**Consultation Response from KC,  
Highways Development Management**

**2022/93344 School Of Dance And Performing Arts, 61-63, Moor Lane, Gomersal, Cleckheaton,  
BD19 4LF**

**Conversion and extension of existing building to form 10 one bedroom apartments and  
associated external works**

**Date Responded: 23/02/2023**

Proposed Site Plan

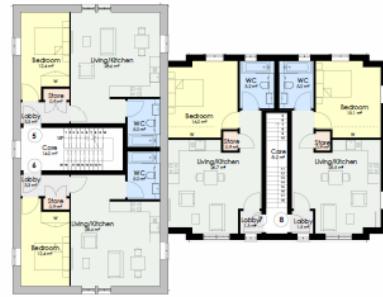
The aisle width between parking spaces 01 and 02, 03 should be a minimum of 6.0m and should be extended for a minimum of 1.0m past the end of spaces 01 and 02 to allow for vehicles to access these parking spaces.

Parking spaces 07 to 10 would be difficult to access and would result in difficult reversing/turning manoeuvres in the area around the main access to the building or potentially reversing the full length of the car park.

The aisle width between spaces 04 to 07 and the building is between approximately 3.5m and 4.5m, again leading to potential conflict between pedestrians and vehicles manoeuvring in this area.

A turning area should be provided at this end of the car park to allow vehicles to access these spaces safely.

The proposal uses the existing vehicular access which, at approximately 6.5m wide is acceptable. However, the proposed location of the refuse store blocks nearly half of the access.

This reduces the width of the access to approximately 3.5m and would not allow two vehicles to pass each other whilst entering or leaving the site.

The refuse store will need to be reduced in width to allow for the vehicle access to remain clear of all obstructions.

An alternative suggestion would be to relocate the refuse store to a point adjacent to the cycle store with a pedestrian access provided on Dewsbury Road. This would also free up more space within the car parking area to allow for a better parking layout.

The proposed location of the refuse store blocks the access to the site and will need to be relocated within the site whilst still being accessible by the refuse collectors.

An alternative suggestion would be to relocate the refuse store to a point adjacent to the cycle store with a pedestrian access provided on Dewsbury Road
